Date: 12 December, 2018

Aughnacurra Residents Association
 C/O 5 Aughnacurra
 Lower Dangan
 Galway
 To:

Planning: **Application Ref:** 07.302848
Submission from: Aughnacurra Residents Association (see Schedule 1)
Applicant: Galway City and County Councils
Development: N6 Galway City Ring Road (N6 GCRR)

Project Number:	6085	Document Number:	VIS-RES1	Revision:	05
Project Name:	N6 GALWAY CITY RING ROAD	Document Title:	RESIDENTS PHOTOMONTAGES (AUGHNACURRA)	Date:	28 September 2018

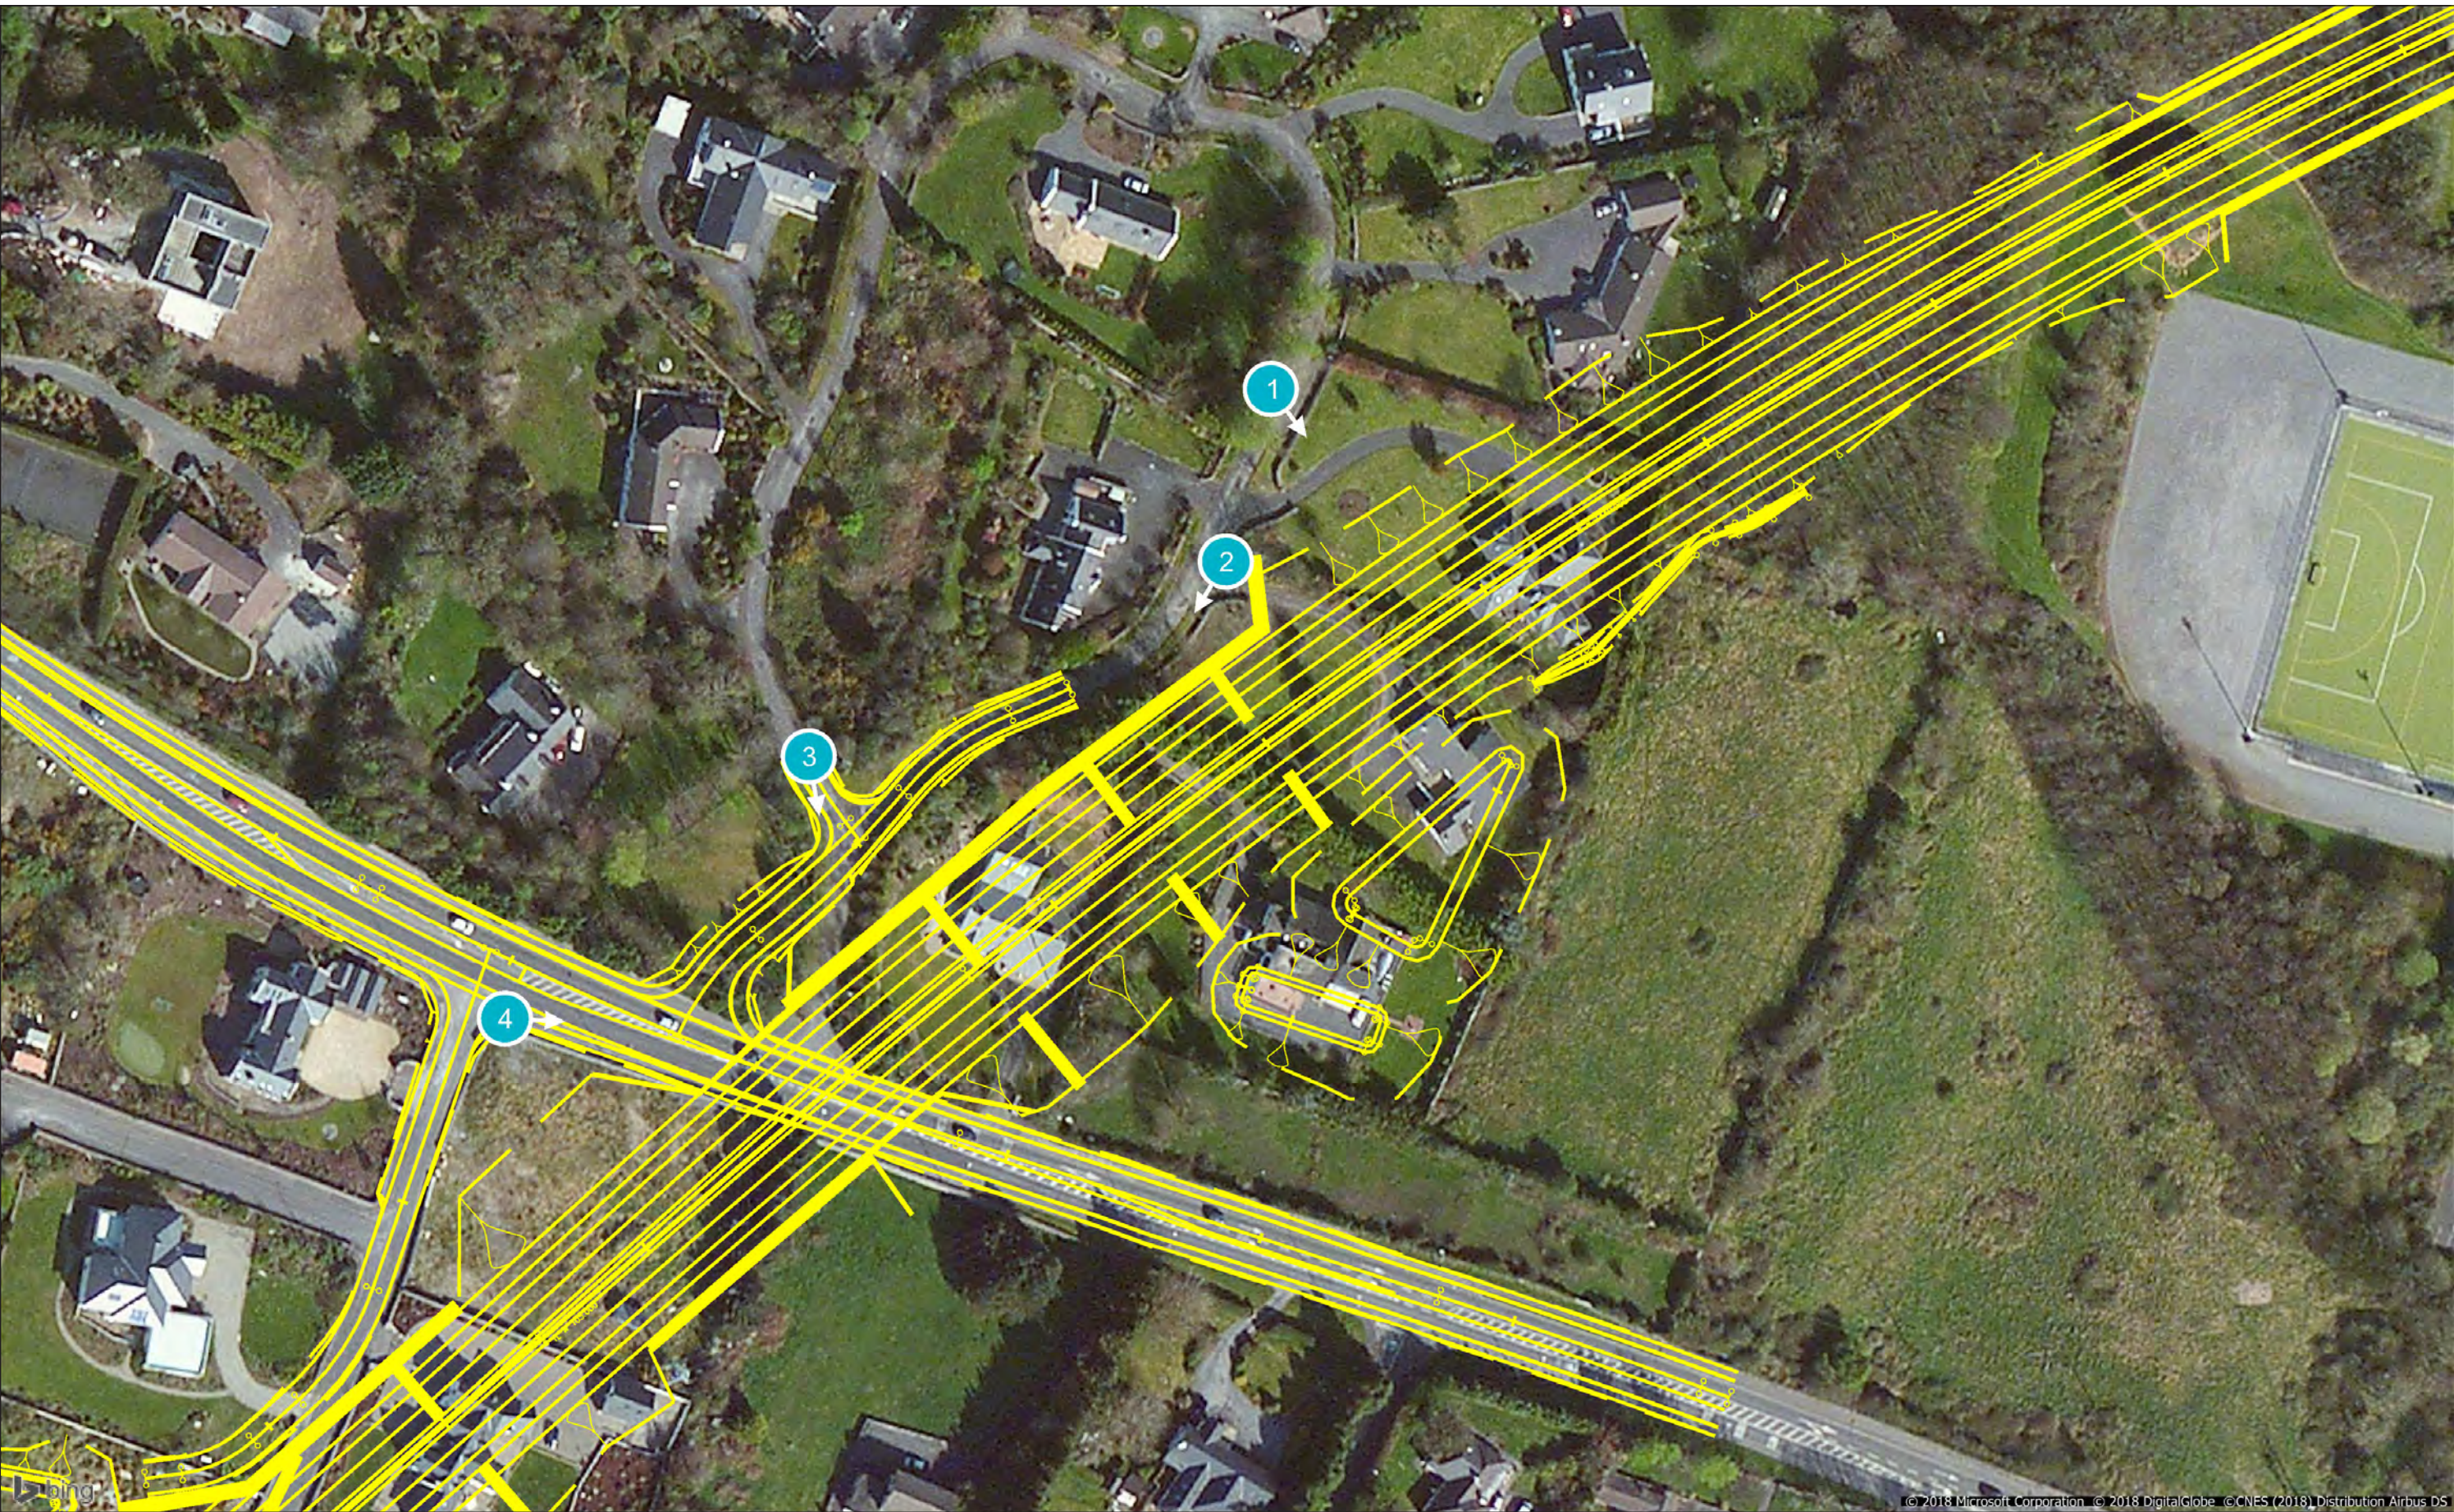
8.1 An uphill gradient is provided to an embankment where the M6 crosses the Estate and the road will be higher than the houses within the Estate and the garden and common areas. More details are required with respect to the embankment as well as sections, walls and railings, landscaping and screening.

9.2 Scheme will result in an elevated structure in front of the houses which will have a significant impact on overshadowing, visual amenity, noise impact, private open space daylight, vibration, illumination and other forms of pollution.

Can you tell me what the blue shaded area with ref 531b.102 relates to in Aughnacurra? I understand the ref 531b.101 shaded in blue as being required to build the motorway, but I don't understand 531b.102, can you explain? Its does not appear to be consistent with the post scheme photmontage of the same plot of land?

In relation to your email below, the lands shaded blue with ref 531b.102 are required for the construction of the proposed road development. These have been shaded blue as an embankment for the proposed road development would encompass this area. We note our discussions with you and your request for this embankment to be replaced with a "green embankment" which will reduce the footprint of the proposed road development in this area and the estate road would remain as the existing situation. This was still under discussion with you and your neighbours at the time of publication and it was an oversight on our part that this plot was not changed from blue lands to grey lands. It has however, been assessed in the EIAR as being a "green embankment" with the estate road remaining as it currently is. We can amend this plot to grey lands as an erratum at the Oral Hearing with An Bord Pleanála. However, as there has been some discussions with you and your neighbours debating your preference for a gentler sloped embankment and concerns with respect to the green embankment can you please advise if you wish to have a meeting to discuss further?
